Middleton-on-Sea Parish Council
7 North Avenue East
Middleton-on-Sea
Bognor Regis
West Sussex
PO22 6HQ

Outline application for the development of up to 250 residential dwellings (Class C3),
vehicular access, public open space, ancillary works and associated infrastructure.
Departure from the Development Plan
Land at Bilsham Road Yapton

Re: Planning Applications Y/91/17 & M/92/17

P:\14-111 - Land West of Bisham Road, Yapton\Tech\Acad\Drawings\Gleeson Drawings for TA\14-111-203 Proposed Comet Corner Junction OPT A.dwg

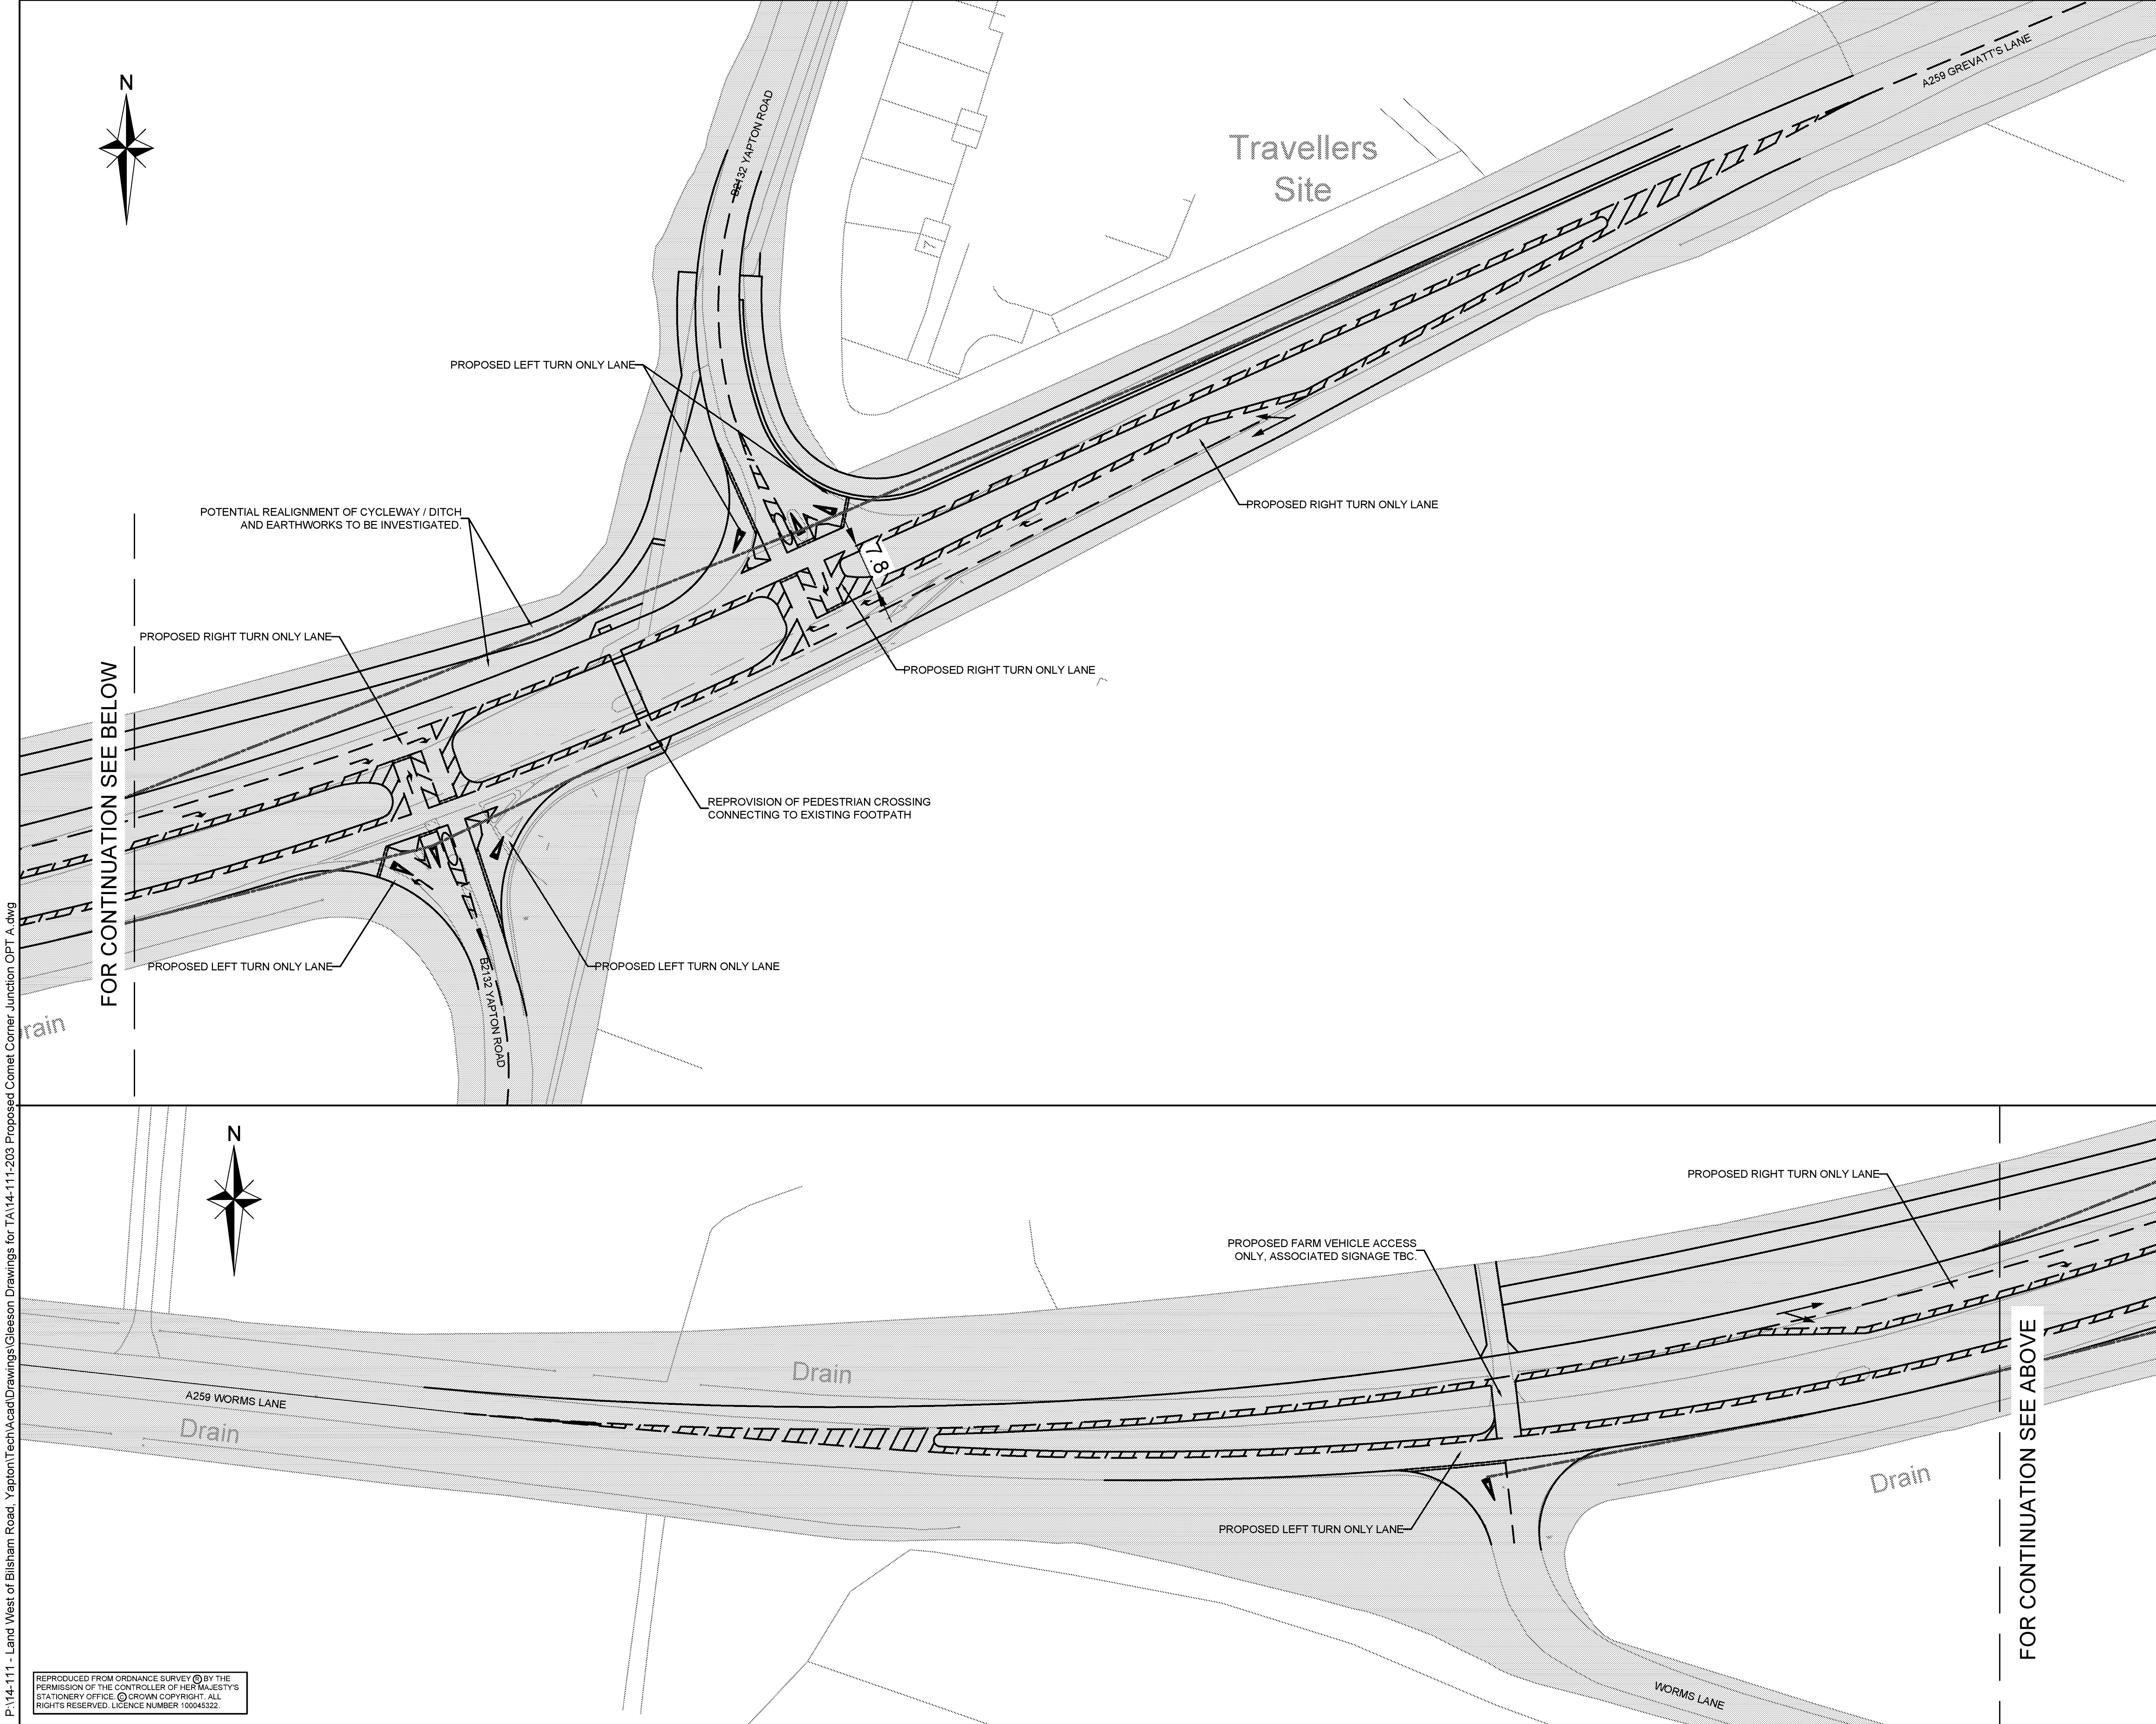
The committee are very concerned that the increase in traffic, especially on the A259 and particularly at the A259/B2132 junction (Comet Corner), will bring potential gridlock in

morning and evening peaks and that traffic wishing to join the A259 from the north or south will be the subject of major delays. Further, significant peer pressure will be felt by the drivers at the head of the queues to exit the junctions which may lead to risks being taken and accidents occurring.

The plans include some proposed work to both junctions but this minor tinkering will make the situation worse. The only solution will be for the developers to fund either traffic signals or a roundabout at the A259/B2132 junction. There is a ready-made plan already held by West Sussex County Council for traffic signals with a price tag of circa £2.5 million so subject to developer funding the project could proceed very quickly.
